I wish to object to the revised plans submitted for the following applications -

Reference - 21/01505/F and 21/01476/LB

Stone Hill House, Stone Hill, Bloxham, OX15 4PT

PROPOSED SOUTH ELEVATION
1: 100 @ A1

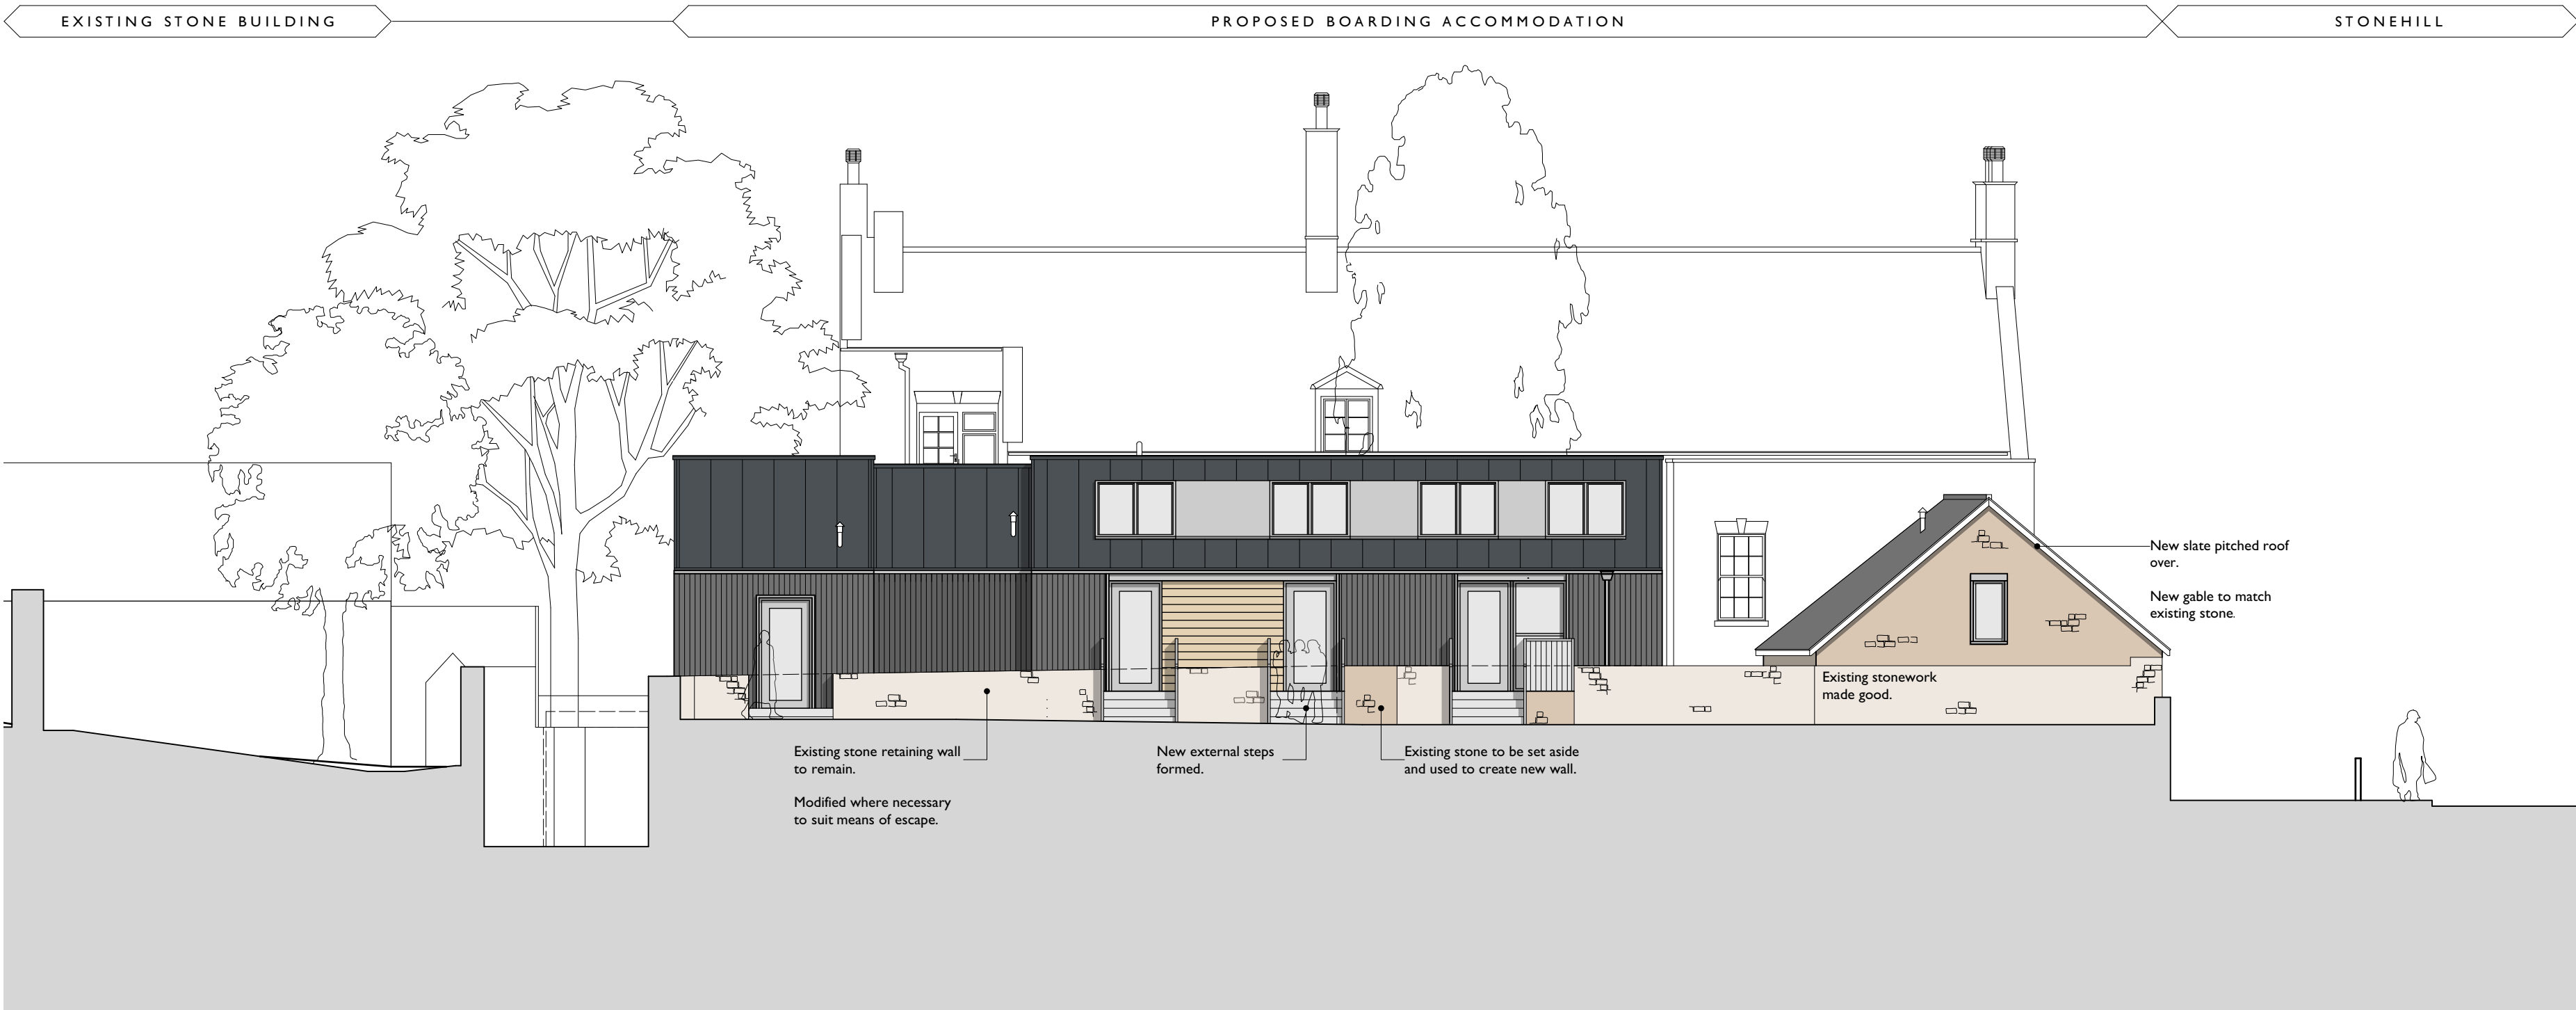
2. The main building materials are still not in keeping with the conservation area. The building will still be visible from further up Stone Hill. The new building will still obstruct the view of the rear elevation of Stone Hill House. The doors and gates with glazed panels are not acceptable.
